# Mallard Pass

**Applicant's Responses to  
Interested Parties' Deadline 2  
Submissions - Other Matters**

**Deadline 3 - June 2023**

EN010127/APP/9.28

Drawing file: EN010127 / EN010127-000209-Figure 06.11_Green Infrastructure Strategy Plan.pdf

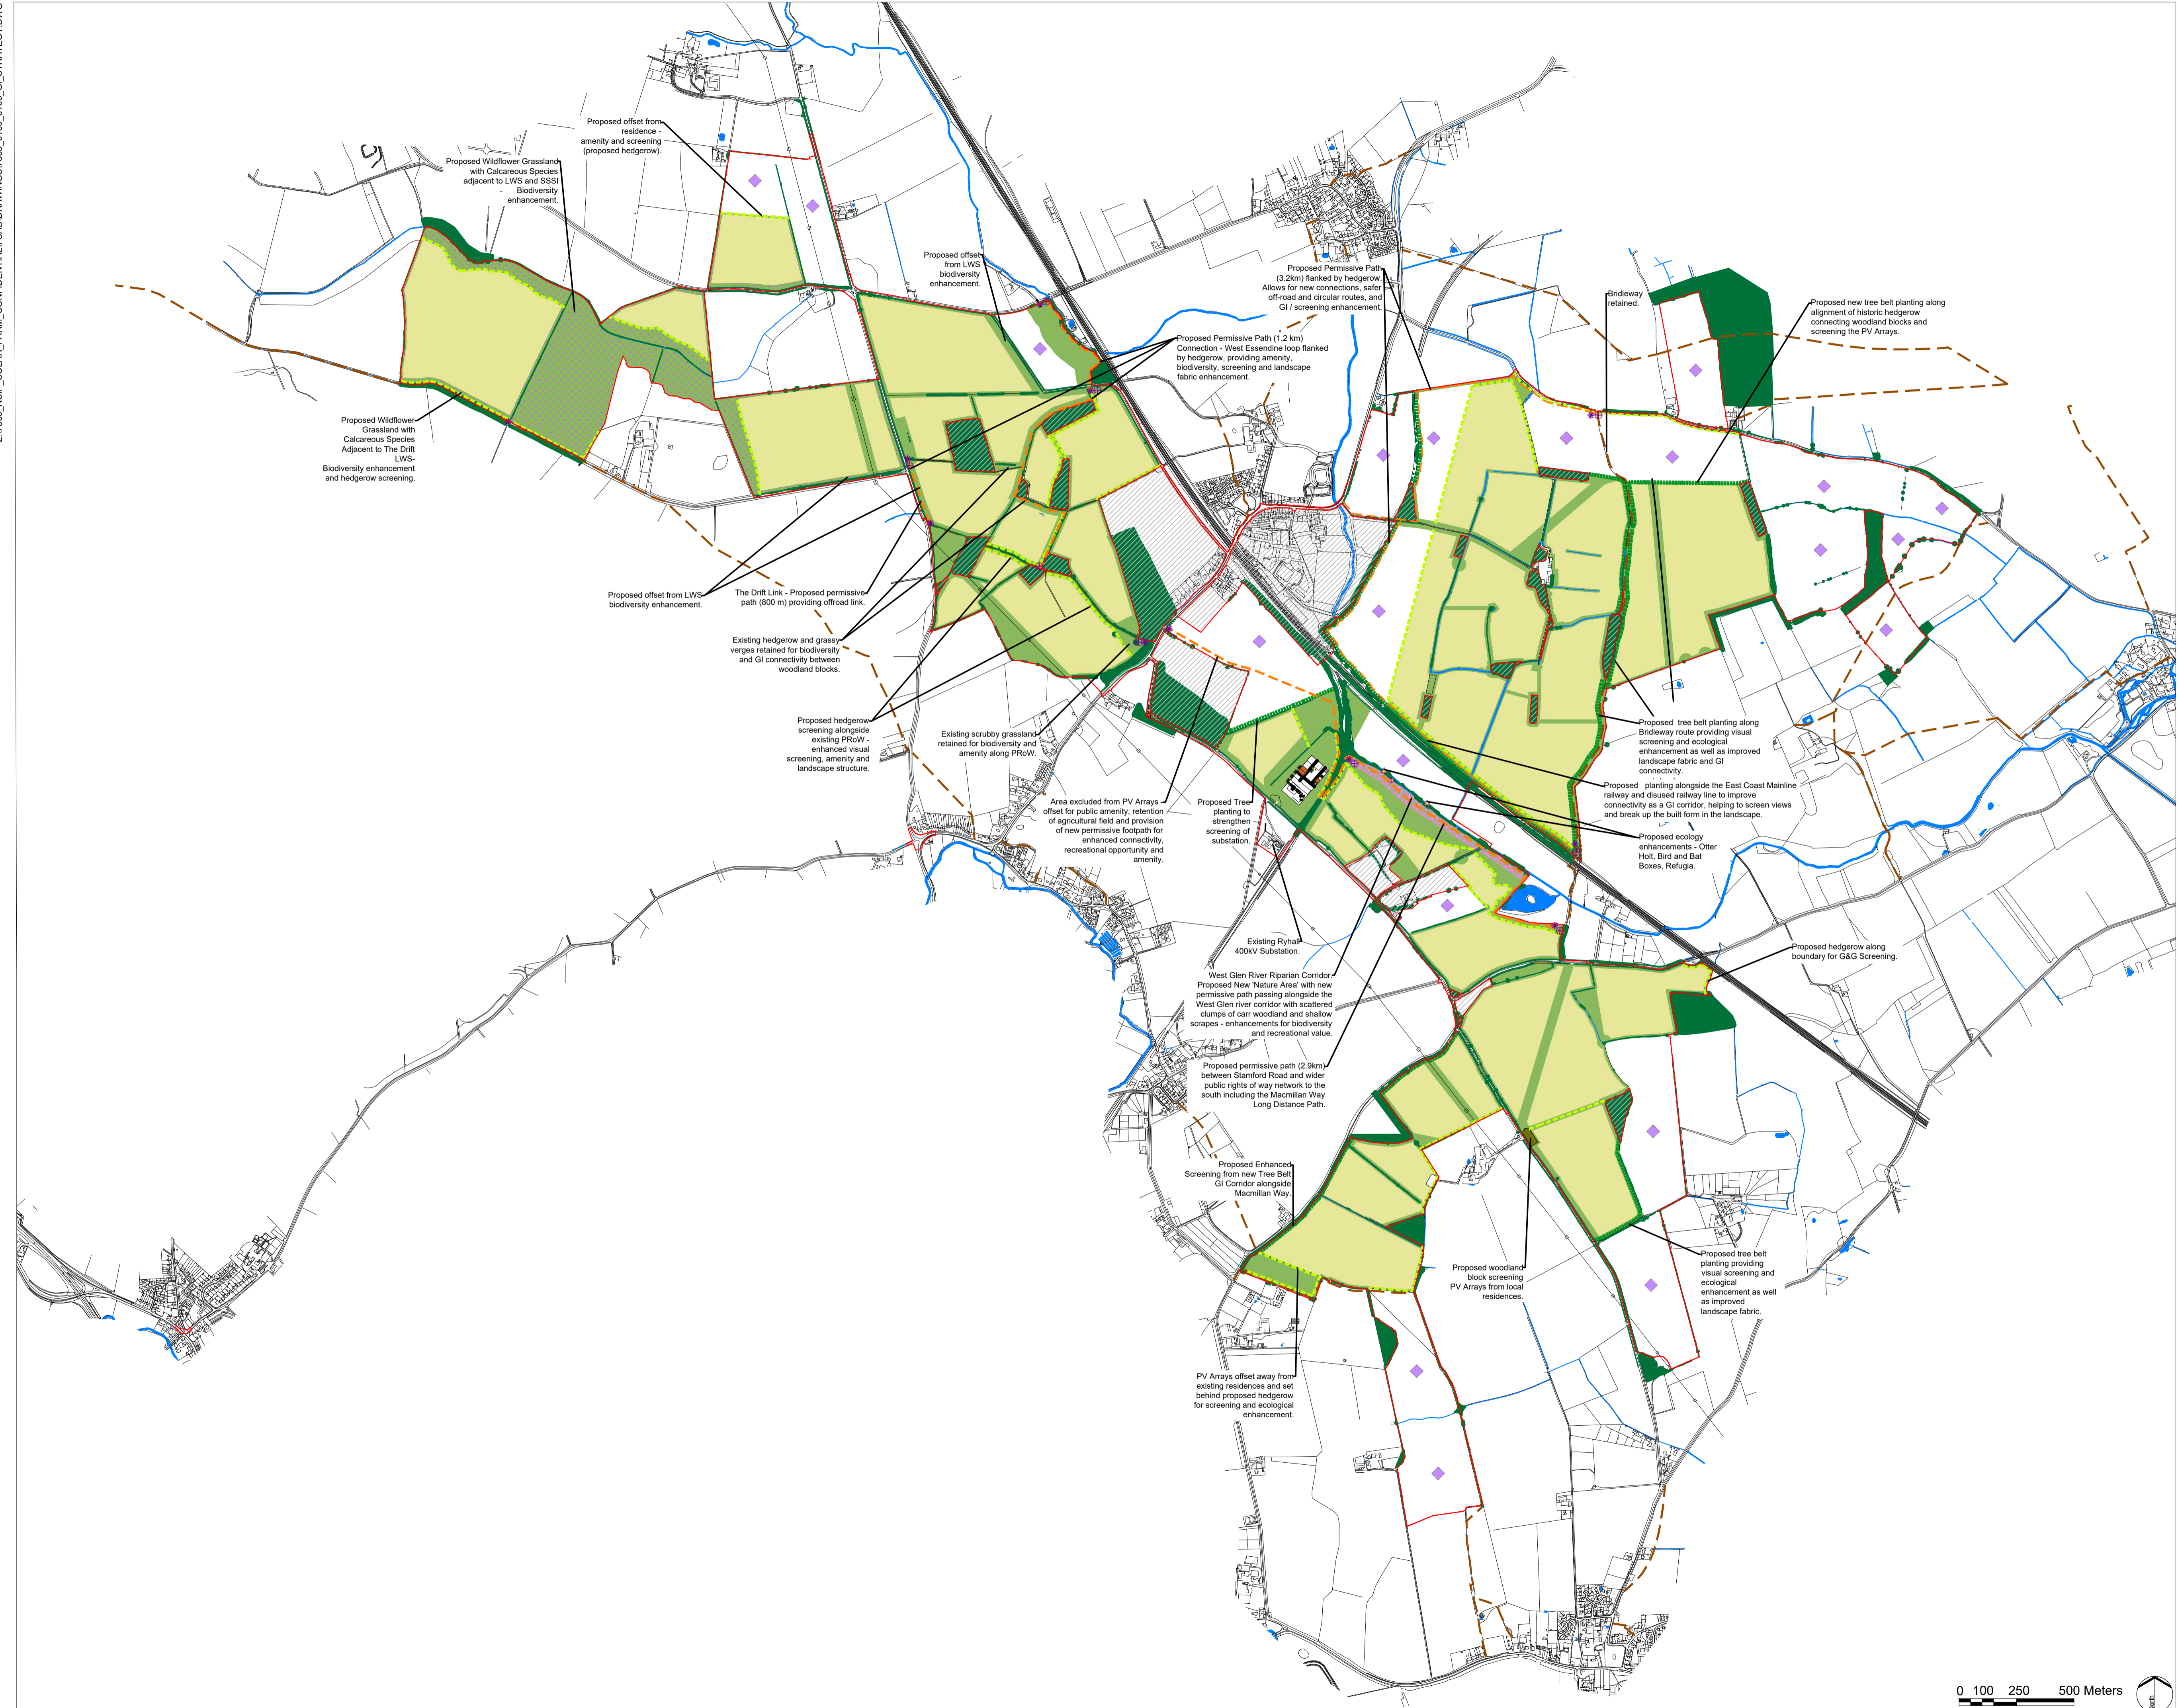
REP2-098	Compliance with trade association commitments	The Applicant is a member of the trade association Solar Energy UK, and the Proposed Development appears to be in conflict with all of Solar Energy UK's 11 Commitments on Solar Farms, especially:	1 - If the UK is going to deliver the amount of renewable energy needed to meet Net Zero, all available grid connections with capacity need to be maximised. The Applicant's response to the ExA's First Written Questions Q1.3.2 and Q1.3.3 [REP-037] explain the ability of substations in the East Midlands to

Parties Raised	Sub-Theme	Issues Raised	Applicant's Response
		<p>1. We will develop on non-agricultural land or land which is of lower agricultural quality where this is available.</p> <p>2. We will enhance the biodiversity and natural capital value of all solar sites, being sensitive and complementing nationally and locally protected landscapes and nature conservation areas.</p>	<p>accommodate new renewable energy capacity and also the reasons why the spare capacity at Ryhall should be utilised.</p> <p>The Applicant has described how it sought to reduce the loss of best and most versatile (BMV) land through the site selection process in response to the ExA's FWQ (Q1.3.6) [REP2-037].</p> <p>The Planning Statement Appendix 1 [APP-203], paragraphs 3.1.6-3.1.12, explains how BMV was taken into account in selecting the site. In particular, the initial site selection was informed by the 2017 Predictive ALC Maps published by Defra which show the Proposed Development as lying within an area with the lowest probability of BMV. In this context, much of the wider area around the site is shown as having moderate or high probability of land being BMV quality (see Figure 12.4 of the Chapter 12 of the ES, Land Use and Soils [APP-042].</p> <p>The Applicant used publicly available information on ALC to inform site selection before undertaking detailed survey work. When the survey work was then undertaken, the Applicant then considered ALC in the scheme design process, as described in the response to Q.1.3.6.</p> <p>2 - The Ecology and Biodiversity Chapter [APP-037] sets out the results of the biodiversity net gain assessment for the Proposed Development. This assessment has shown that the habitat creation and enhancement being proposed will provide a high net gain in biodiversity value for the area . This has been shown to be just over 72.19% for habitats and 40.83% for hedgerows with the use of the Biodiversity Metric 3.1, carried out on the basis of the Green Infrastructure Strategy Plans set out within the oLEMP. This constitutes a beneficial effect. The principles of the Green Infrastructure Strategy are the reconnection of existing habitats and designated ecological sites through new woodland, grassland and hedgerows planting that is reflective of local soil conditions and existing species and as part of landscape scale GI enhancements and facilitating a network of permeable 'wildlife corridors' throughout the Order limits. The diagram on page 49 of the Design and Access Statement [REP2-018] illustrates</p>

Parties Raised	Sub-Theme	Issues Raised	Applicant's Response
			conceptually the principles of the Green Infrastructure Strategy provide at Figure 6.11 [APP-173] and also with outline Landscape and Ecology Management Plan [APP-210].
<p>REP2-126  REP2-090  REP2-193  REP2-169  REP2-143</p>	<p>The consent is not time limit and has uncertainty around design and timescale.</p>	<p>There is no time limit on the planning consent for this development. There need to be clear timelines if the assumptions and promises in the application are to be feasible and accountable.</p> <p>The absence of a time limit requires the application to be considered permanent and none of such logic has been applied to the Application.</p> <p>The Applicant also has not justified deviation from the typical 40-year life span (as per Draft EN-3).</p> <p>Difficult to assess all impacts when the timeframe is unknown.</p>	<p>As set out in Chapter 5 of the ES [REP2-012] the operational life of the Proposed Development is not proposed to be specified in the DCO and the Applicant is not seeking a time limited consent. The EIA has been carried out on the basis that the Proposed Development is permanent, to ensure a worst-case assessment of likely significant effects. Notwithstanding this, it is considered that effects are reversible once decommissioning take place, pursuant to the mitigation measures secured through the draft DCO.</p> <p>The operational life of the Proposed Development has not been specified within the DCO Application. However, it is recognised that the electrical infrastructure will have an operational lifespan. As such, for the purposes of assessing decommissioning with the ES, it has been assumed that the Proposed Development has a 40-year operational life span to enable an assessment of decommissioning to be carried out. The operation assessment does not assume that the operational phase will be limited to 40 years as the solar infrastructure may continue to be operating successfully and safely beyond this period.</p> <p>The independent Environmental Statement review (Appendix D) that was undertaken by Barton Willmore (now Stantec) on behalf of Rutland County Council and South Kesteven District Council concludes that the ES:</p> <ul style="list-style-type: none"> <li>• is in compliance with the Infrastructure EIA Regulations' requirements;</li> <li>• is in compliance with the requirements of Advice Note 7;</li> <li>• comprehensively identifies and assesses the likely significant effects of the proposed development;</li> </ul>
